HILLS OF GOLD PRESERVATION INC 1800437

OBJECTION

PUBLIC SUBMISSION TO THE ENVIRONMENTAL
IMPACT STATEMENT FOR HILLS OF GOLD
WIND FARM PROPOSAL ID NO.SSD9679

Figure 2: Corrected LSC mapping with broad development footprint provided by SOMEVA

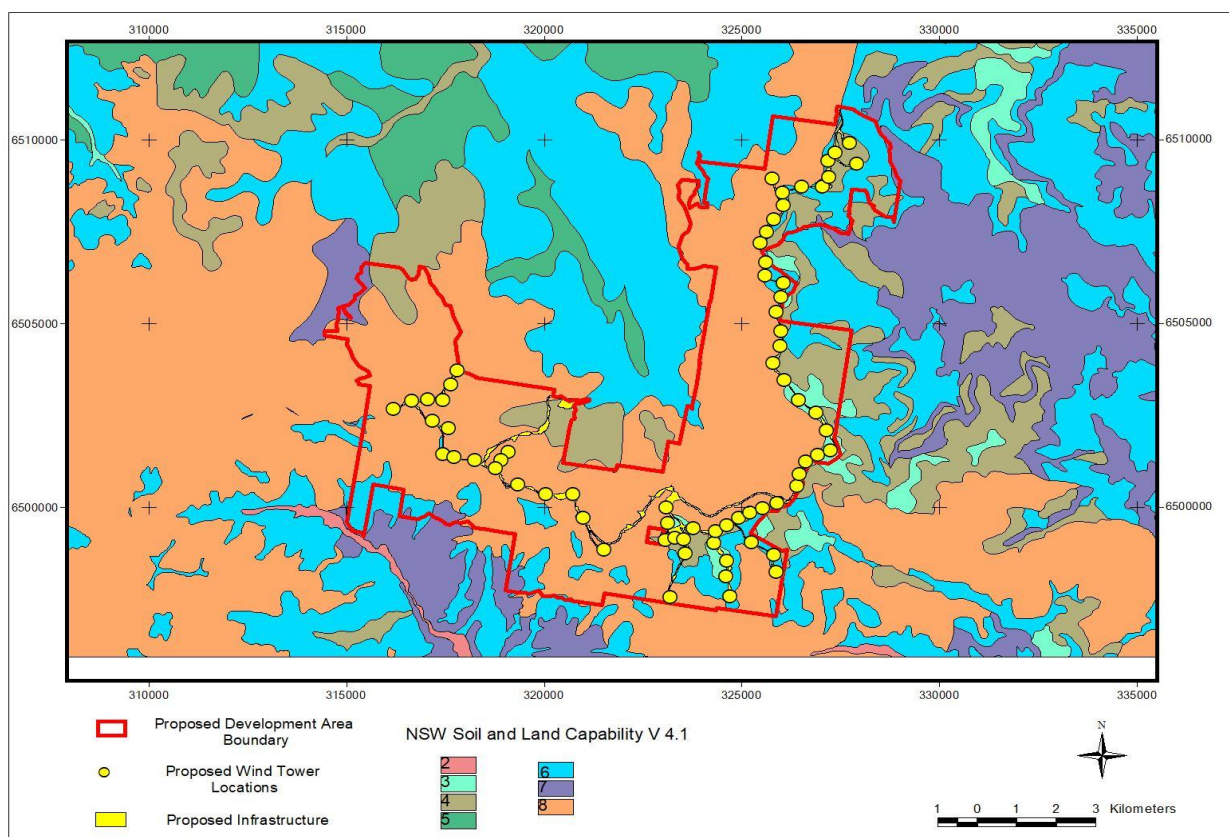
Dr Banks identified a significant error in Land Soil Capability coding, which has been corrected in the state database following necessary NSW Government protocols. It is expected to be updated online by the end of January. The LCS maps in the EIS and Appendix are incorrect. Revision of mapping gives more serious weight to erosion hazard within the project development, raising it from “low to moderate” to “high to extreme”. Around half of the proposed development and 33 wind turbines are on mass movement dominated land with very high erosion risk.

Modelling of erosion hazards using soil information from 577km away from the proposed development is misleading, and statements and conclusions made in the EIS and Appendix O are incorrect.

- redo Soil and Water Assessment based on correct Land and Soil Capability mapping, paying particular attention to Class 8 soil, high erosion and mass movement risk.

Figure 4: Modeled Rainfall in Region around Development Area

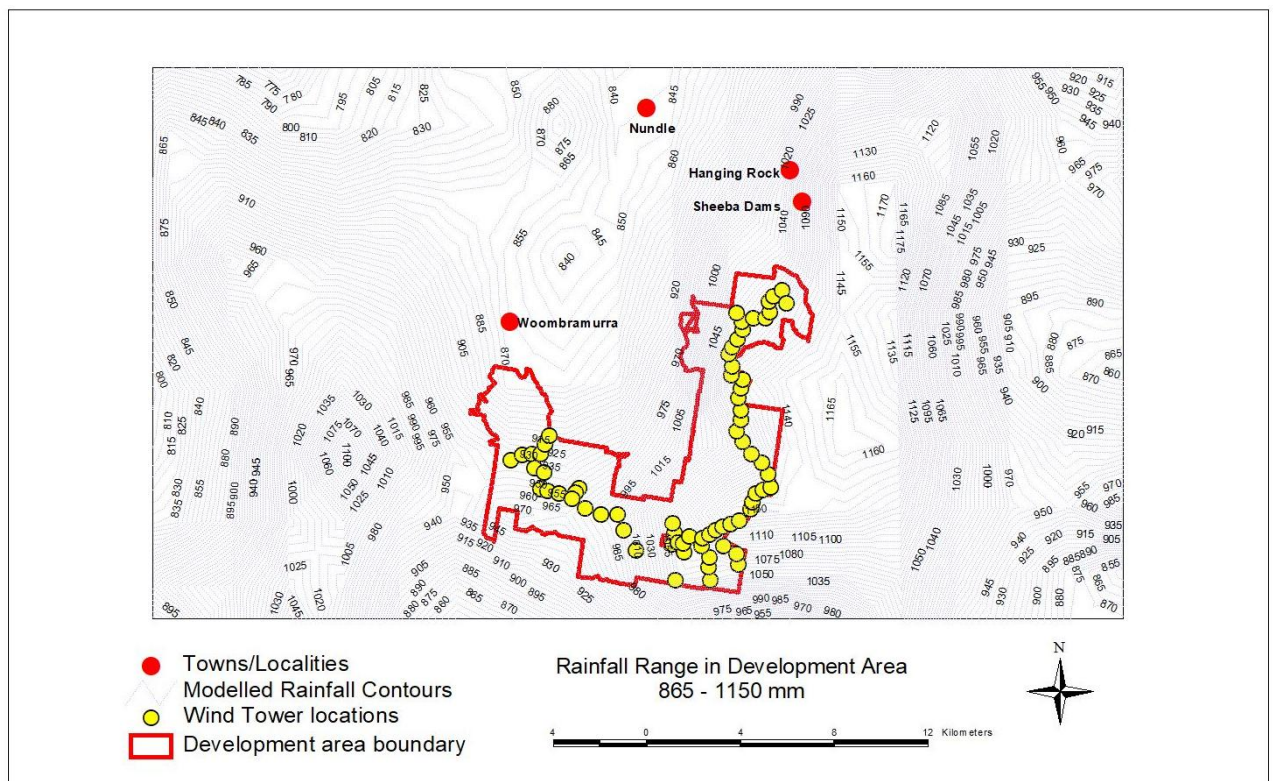
Modelled rainfall surfaces for Nundle and surrounds indicates that the amount and intensity of rainfall within the Project Area is up to 50% higher than that provided for Nundle. Flooding of crossings used by heavy transport vehicles on the floodplain has been ignored and must be taken into account.

- conduct on site soil survey and use results in modelling of erosion hazards.
- use Hanging Rock rainfall modelling (up to 50% higher than Nundle Post Office) and use figures to inform runoff and erosion mitigation.
